Letter of Intent

Requesting administrative special use for extended family dwelling for elderly parents requiring higher level of care.

14330 Chalet Ln
 Elbert CO, 80106-8881
 Date: 01/04/2021

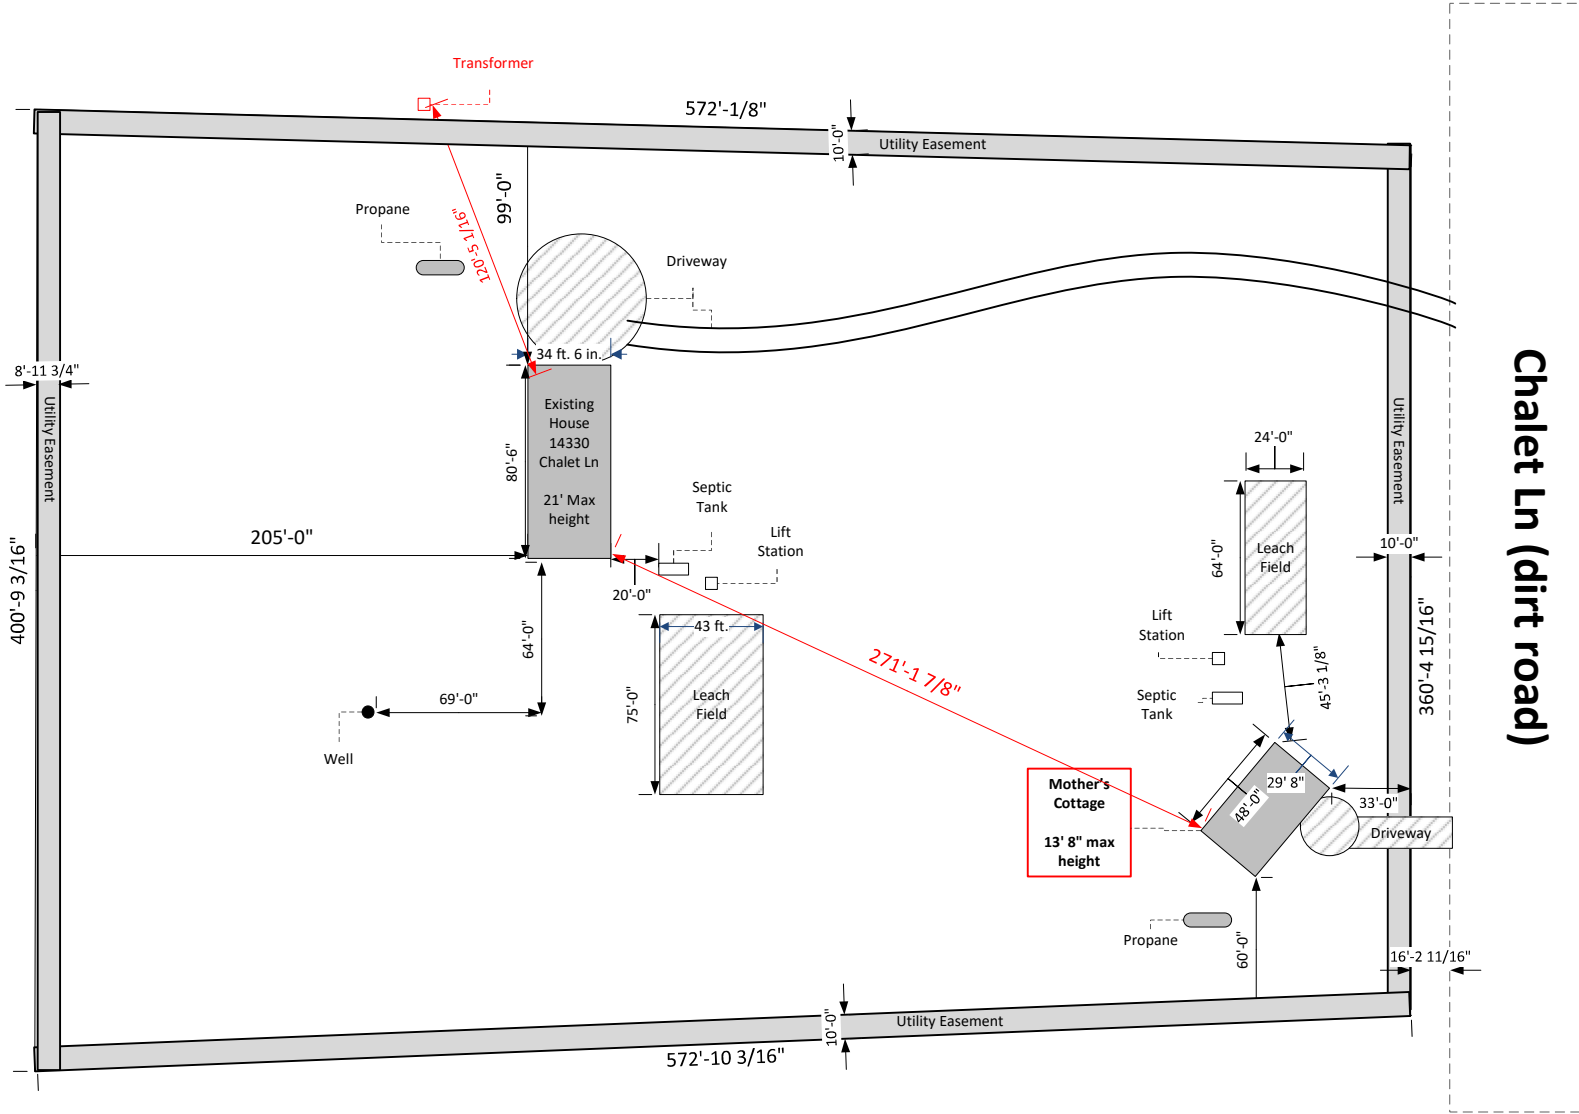
There is no driveway access permit on file for existing driveway. A driveway access permit is required for all access points onto a county or private road within unincorporated El Paso County. Please apply for a driveway access permit for the existing driveway and a separate secondary access permit for the proposed driveway. Instructions will be provided in EDARP.
